Application No: FP/1/25/HH

Site Address: 2 Leverton Avenue Felpham PO22 7RA

Description of works: Retrospective application for erection of a side boundary fence.

updated block plan

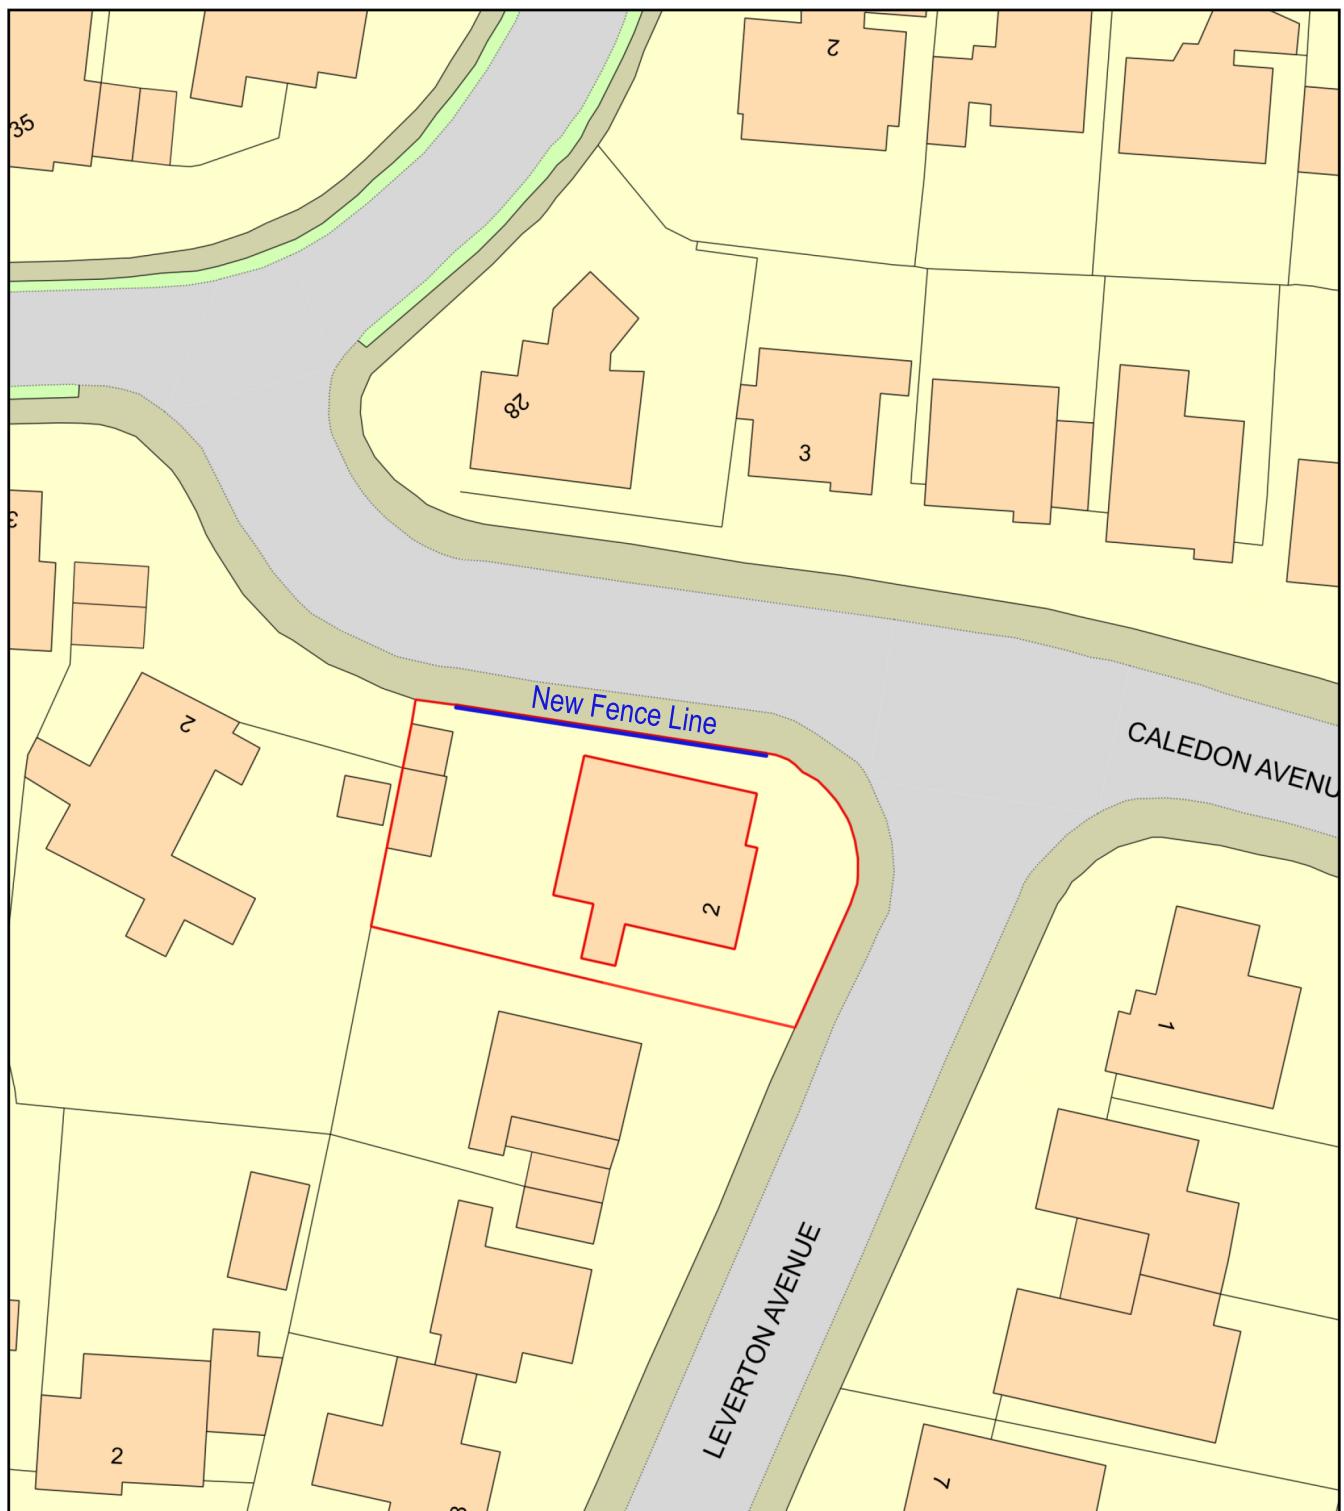
The boundaries on the estate must have a green border in front on them and are not allowed to be sited right up to the pavement. Other properties have put in planning before erecting fences and all have been denied unless there is a gap between the fence and the pavement, which should have either grass or a green hedge in front of it. The parish council have also denied applications on this basis.
